Developer Services
Southern Water
Sparrowgrove House
Sparrowgrove
Otterbourne
Hampshire
SO21 2SW

Your Ref
LU/345/18/DOC
Our Ref
PLAN-025911
Date
14/12/2018

Proposal: Approval of details reserved by condition imposed under ref LU/47/11/ relating to Condition Nos 10 surface water drainage scheme, 11 future access to & maintenance of any watercourse or culvert, 12 discharges of any flows to watercourse, 13 foul water drainage system.
Site: Land North of Toddington Lane, Littlehampton, BN17 7PP.
LU/345/18/DOC

Figure 2.1: Typical Permeable Block Paving Construction

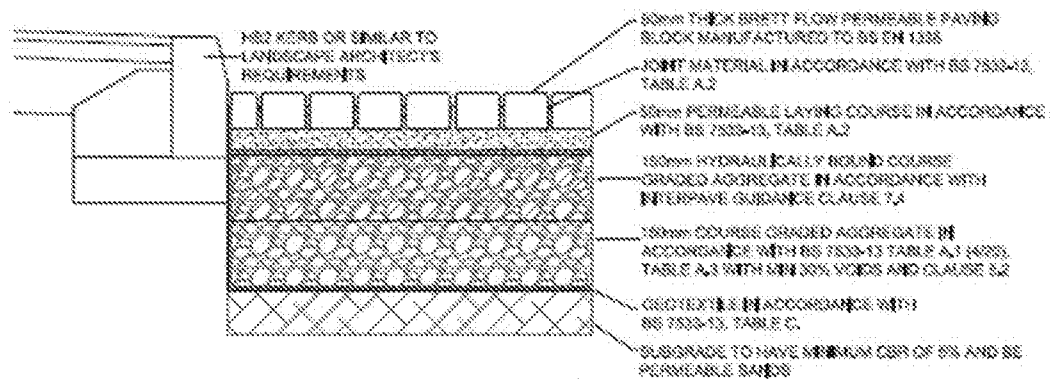
Southern Water would have no comments to make with regards to means of surface water discharge to watercourse and access to this feature. However the details of the surface water drainage as covered by condition 10 do not seem to be satisfactory. The surface water drainage, although proposed to be designed to adoptable standards, does not seem to comply with such standards and Southern Water requirements. The matters that will not be considered as adoptable by Southern Water may include: online

attenuation facilities; connection of swales, soakaways, filter drains and other features introducing land drainage and groundwater to adoptable drainage; construction of tanked permeable paving and attenuation/ storage tanks over sewers offer for adoption.
